**Our Ref: AB/89/18/PL**  
**Your Ref:**

**Town & Country Planning Act 1990 (as amended)**  
**Town and Country Planning (Development Management Procedure) (England) Order 2015**  
**Application for Planning Permission**

**Development** Change of use of loft space from office storage to office work space & installation of roof light. This application affects the character & appearance of the Arundel Conservation Area.

**Location** 65 Tarrant Street Arundel

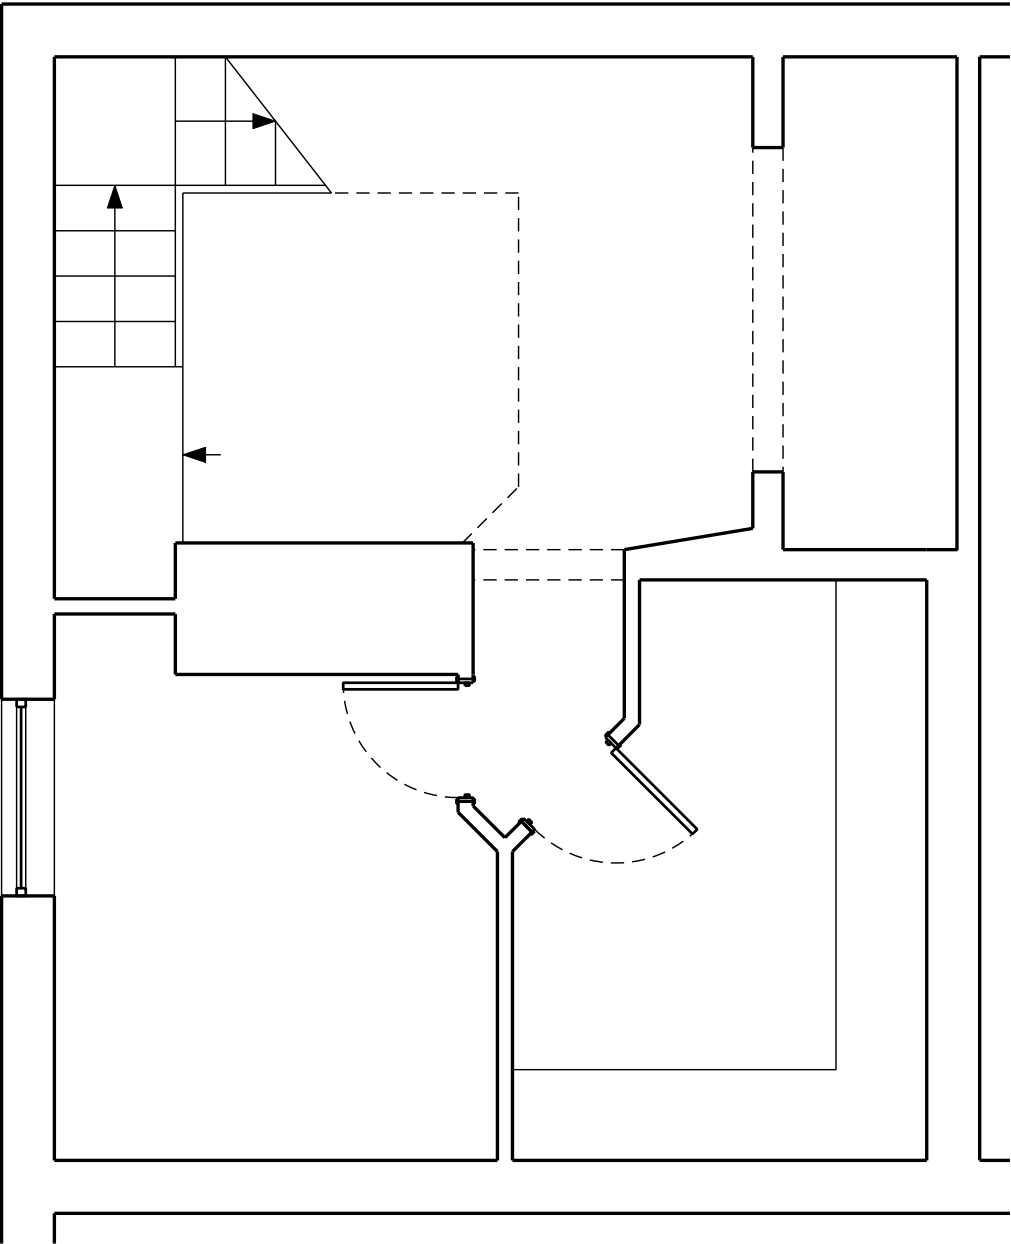
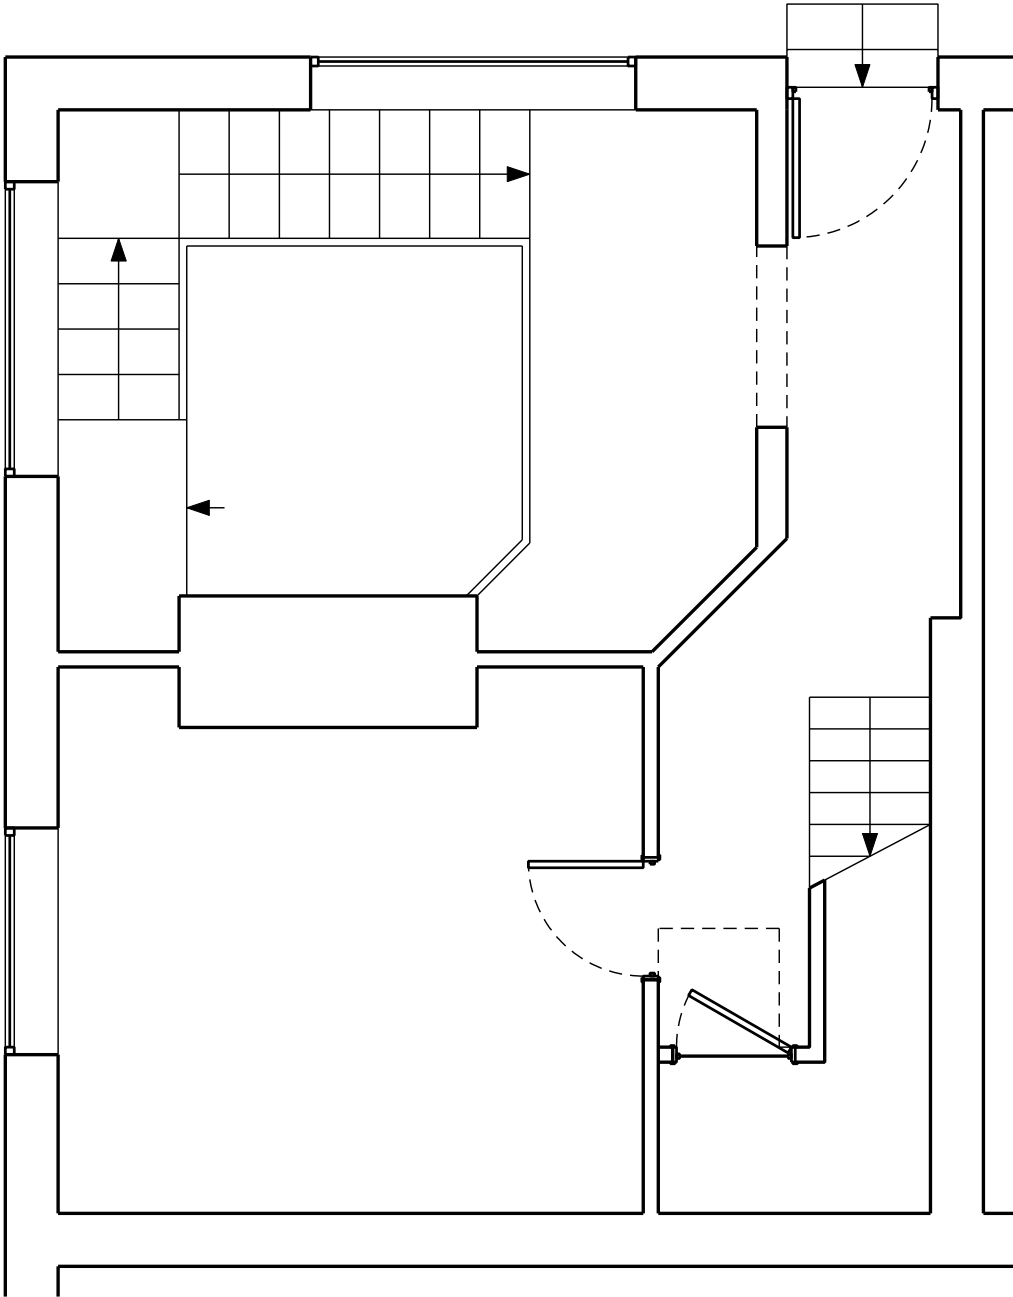
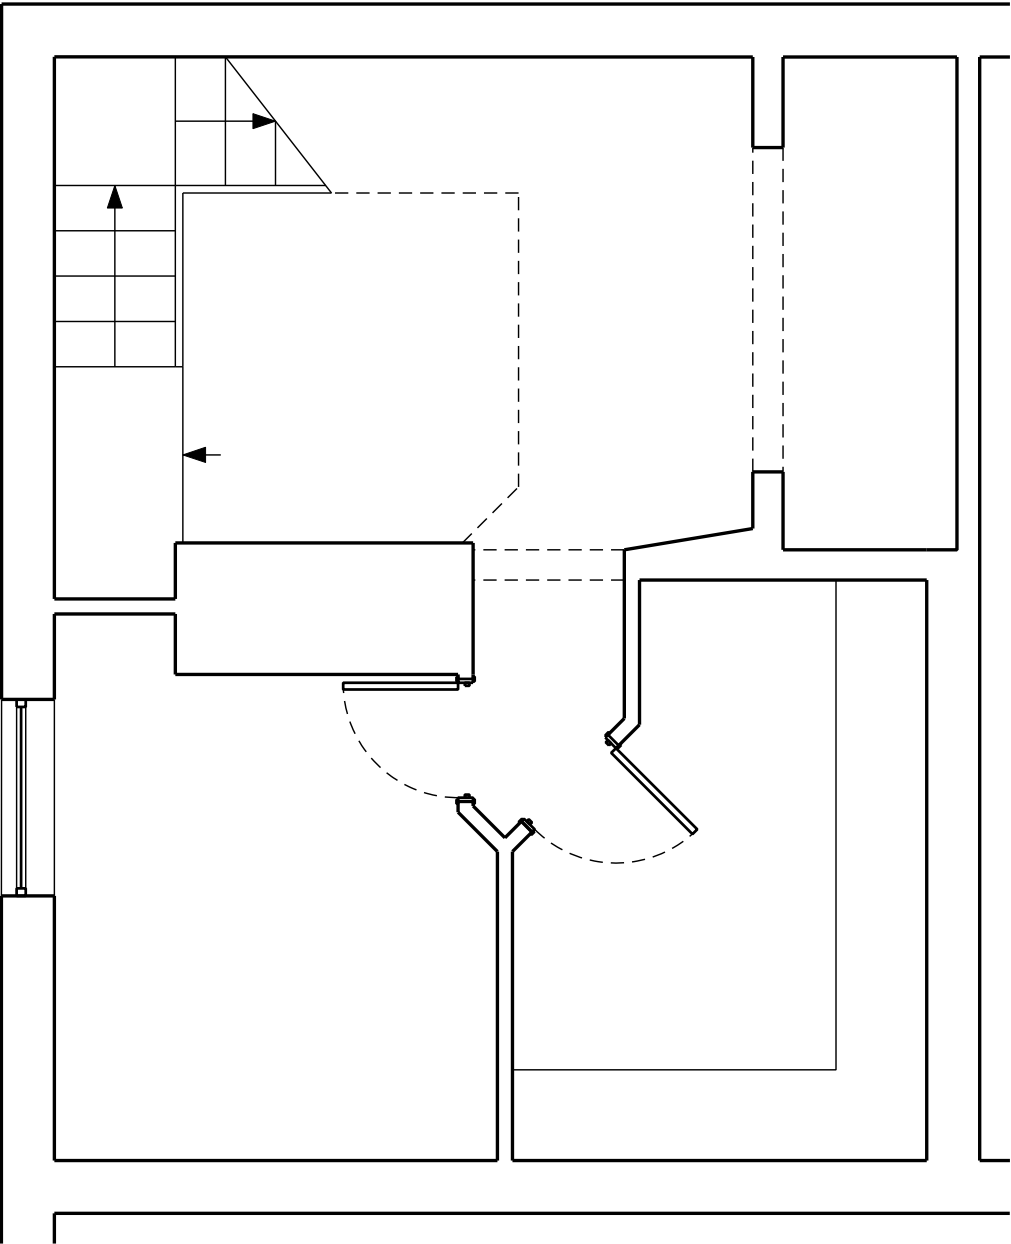
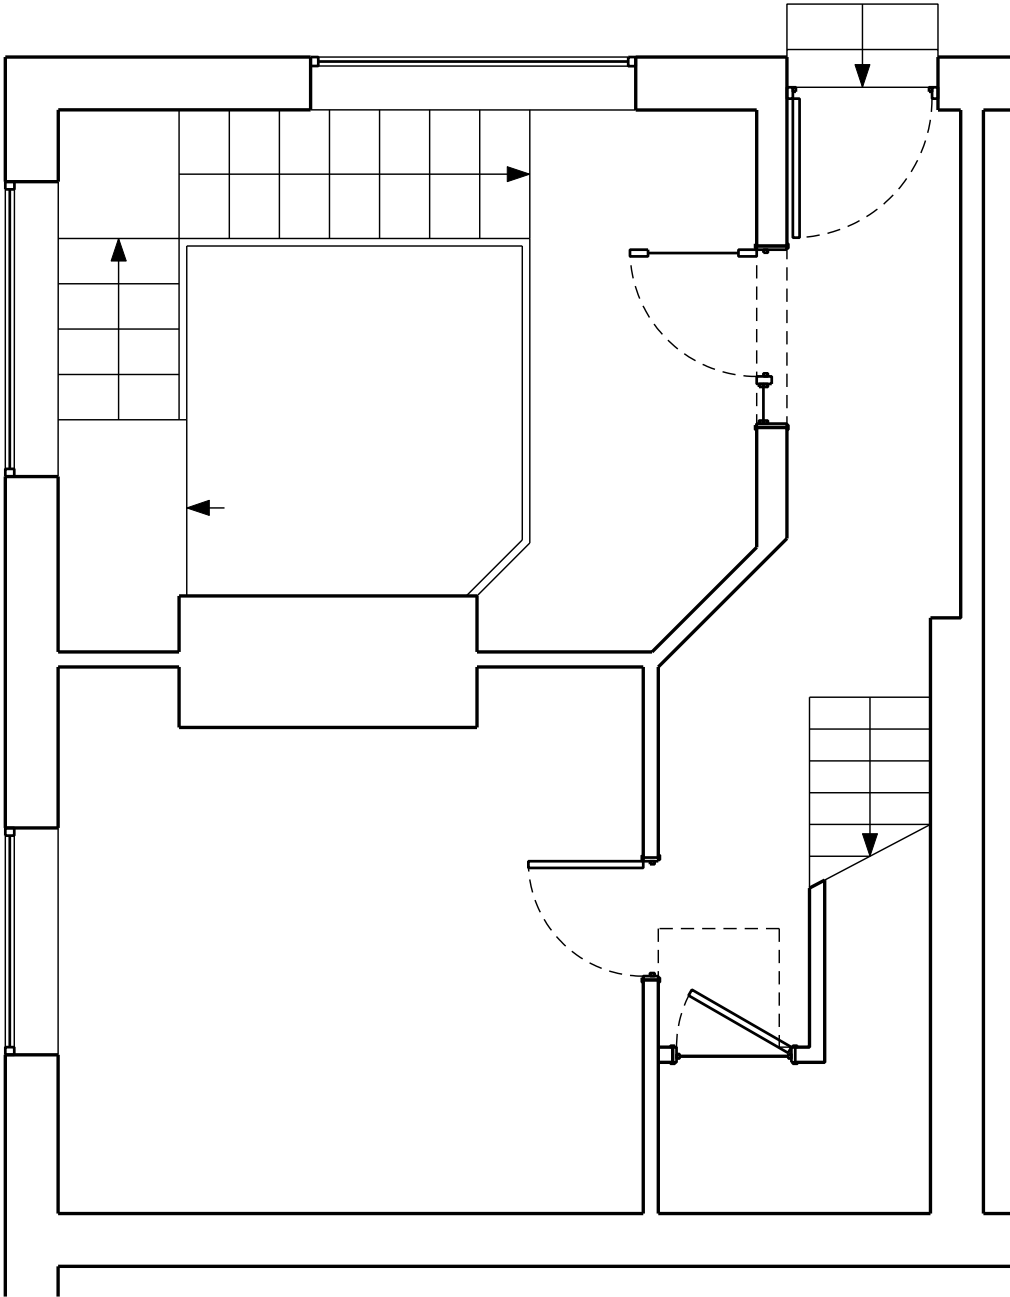
The existing and proposed basement and ground floor plans and the Arun Street elevations do not accord. Please amend accordingly.
